15 November 2019

File No: 2019/572869
Our Ref: R/2014/33/I & R/2018/13/A
Your Ref: MP 06_0171 MOD 16 & SSD-9374

Request for advice – Modification of Central Park Concept Plan (MP 06_0171 MOD 16) and Block 4B Central Park Adaptive Reuse (SSD-9374)

Northern Elevation

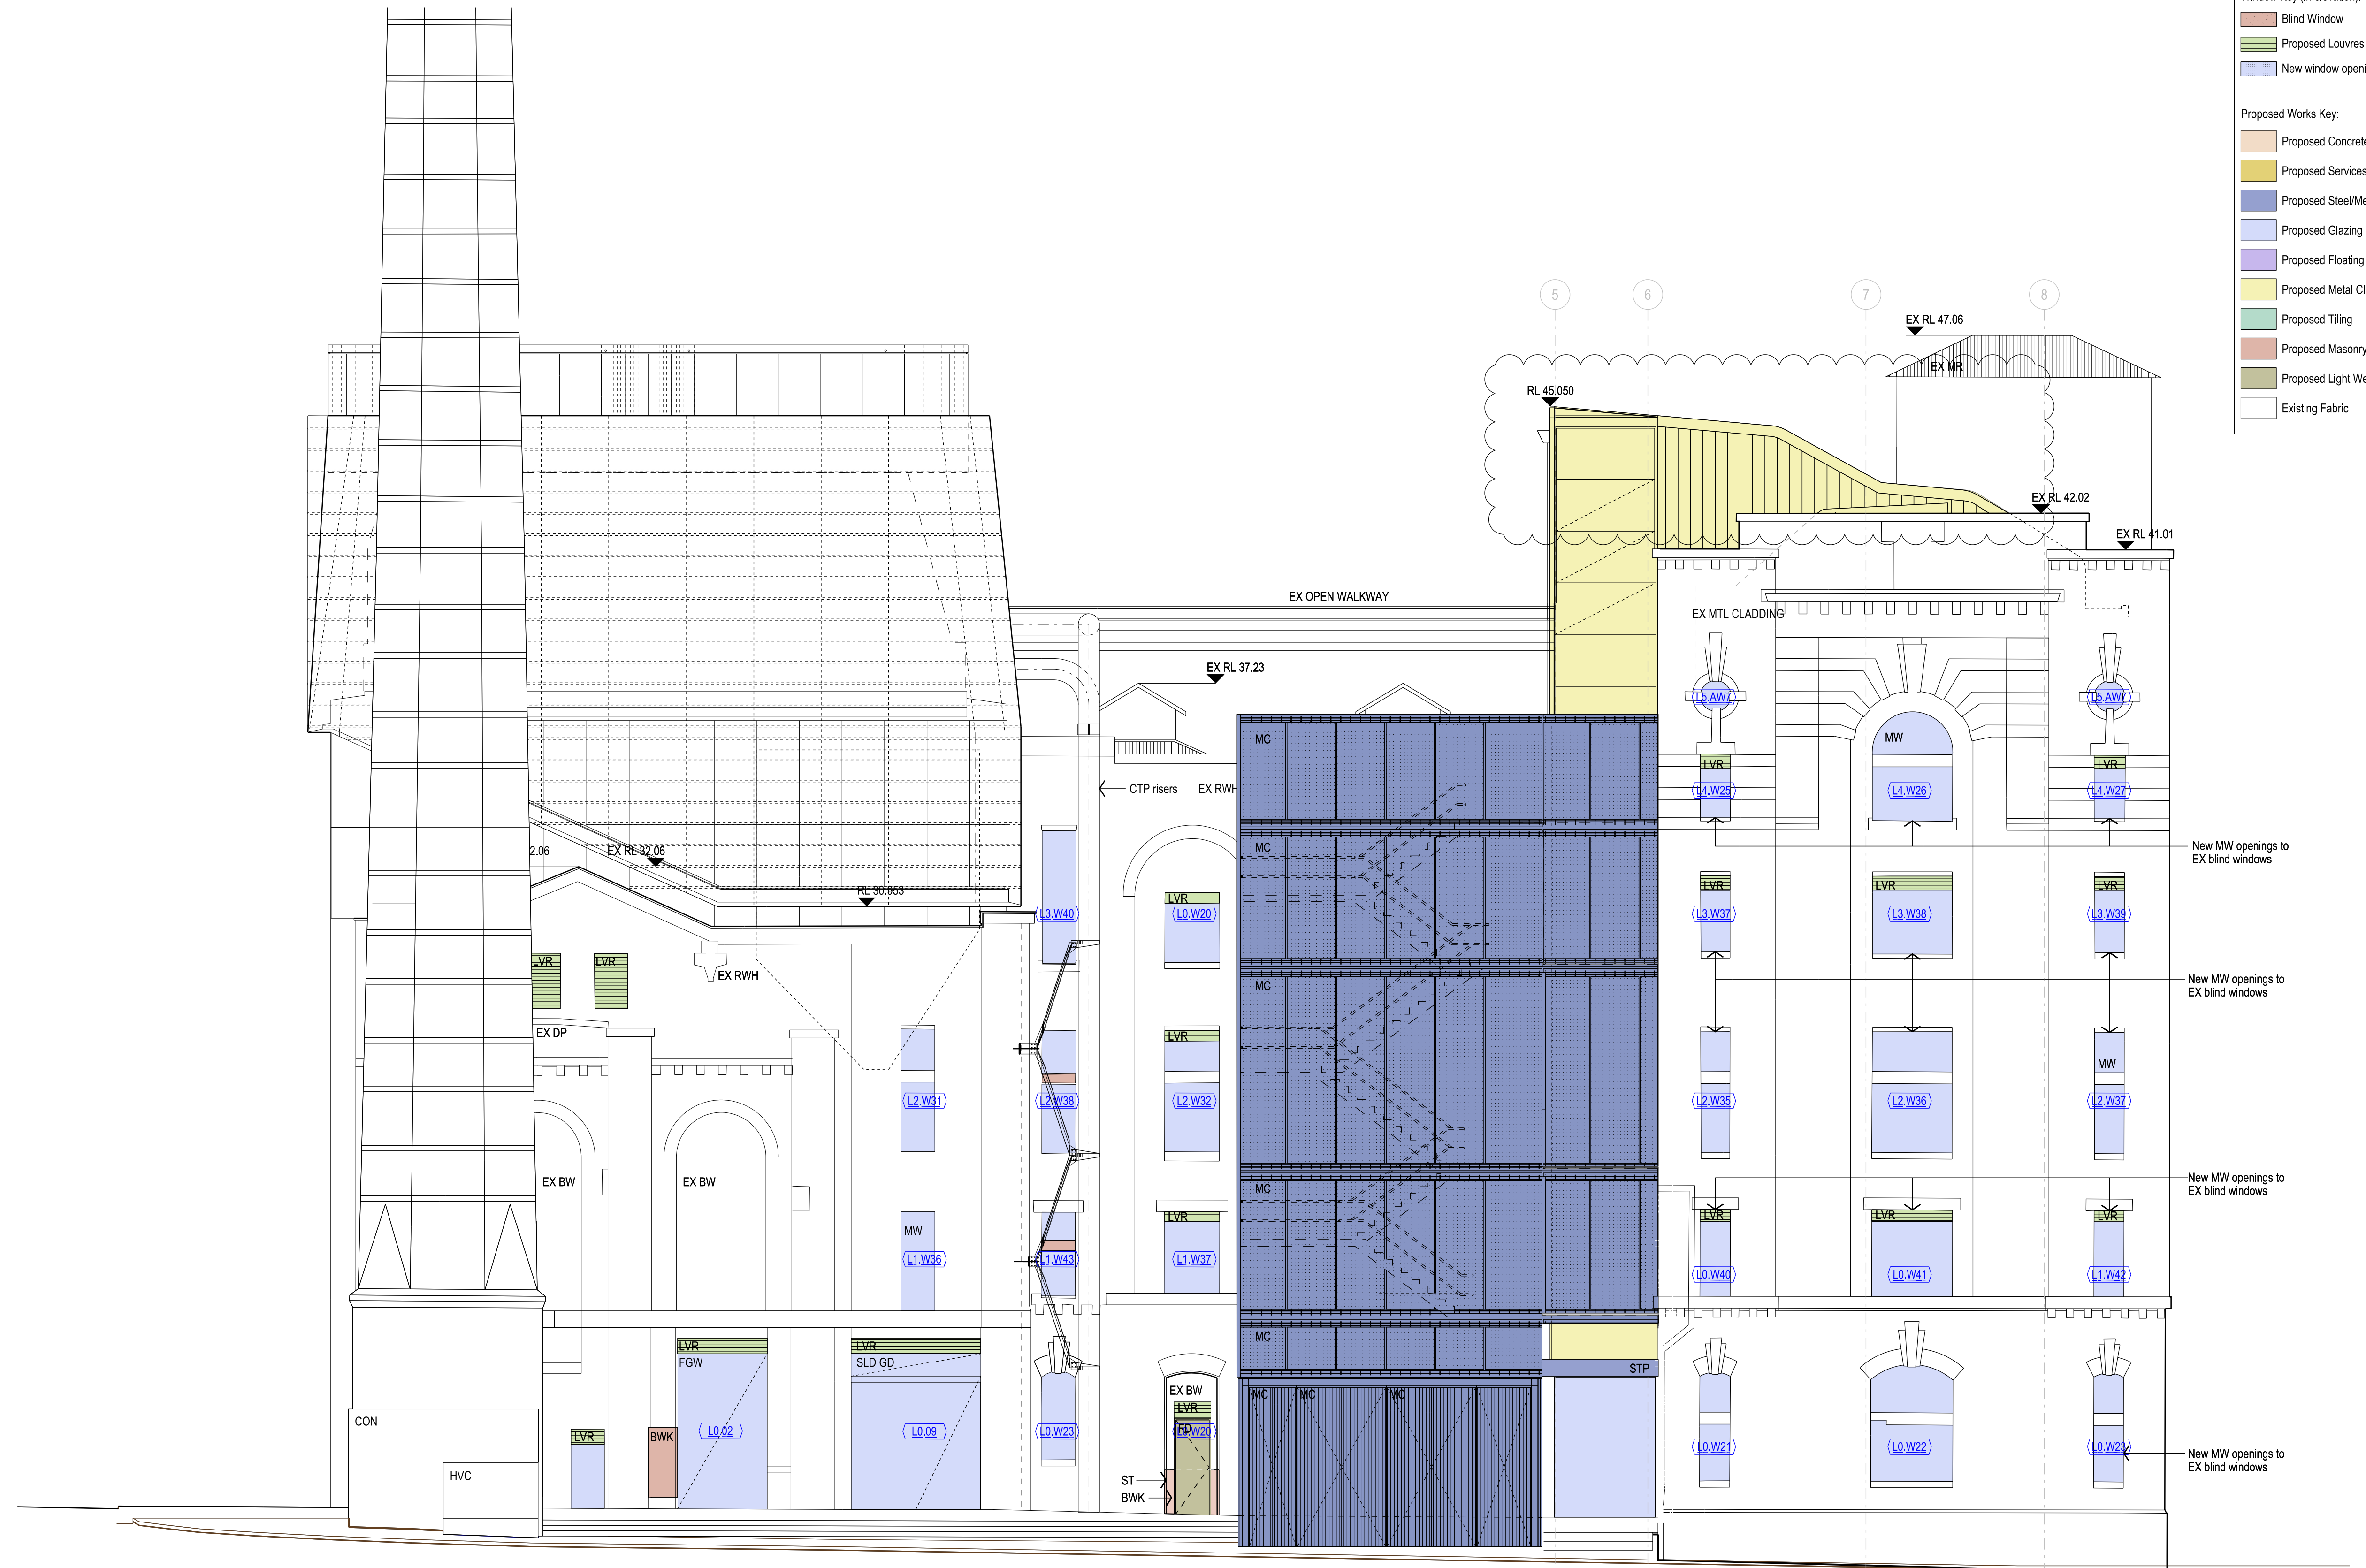
The City is concerned that the proposed works will impact the existing design integrity of the northern façade and the northern part of the eastern façade.

The original approved design of the completed cooling towers included a deep, angular 'bird's mouth' recess between the underside of the cooling towers and the top of the glass facade. This was intended to make an emphatic articulation between the old building and the new cooling tower on top and was a key heritage and design justification for the approval of the large and contemporary form of the cooling tower. The pitch angle of the lower surface of the recess was to match that of the original roof that was demolished to make way for the towers and also matches the angle of the surviving east brick and stone parapet. The existing steelwork on site is in place for this but the cladding and glass facade were not constructed.

This strong and desirable approved articulation has been diluted in the current proposal, most likely to provide additional clearance for the proposed, intrusive additional floors in this area. This is an unacceptable change to the original design intent and is not supported. The design should be amended to retain and complete the 'bird's mouth' articulation as originally approved.

I also note that the existing steel work spans the full width of the void under the existing cooling towers. The additional columns proposed to support the new, intrusive floors also dilute the clarity of the originally approved design for this area. The design quality of the first stage of this multi-award winning adaptive design project is less in the current proposal and its heritage impacts are far worse with substantial loss of significant internal and external fabric.
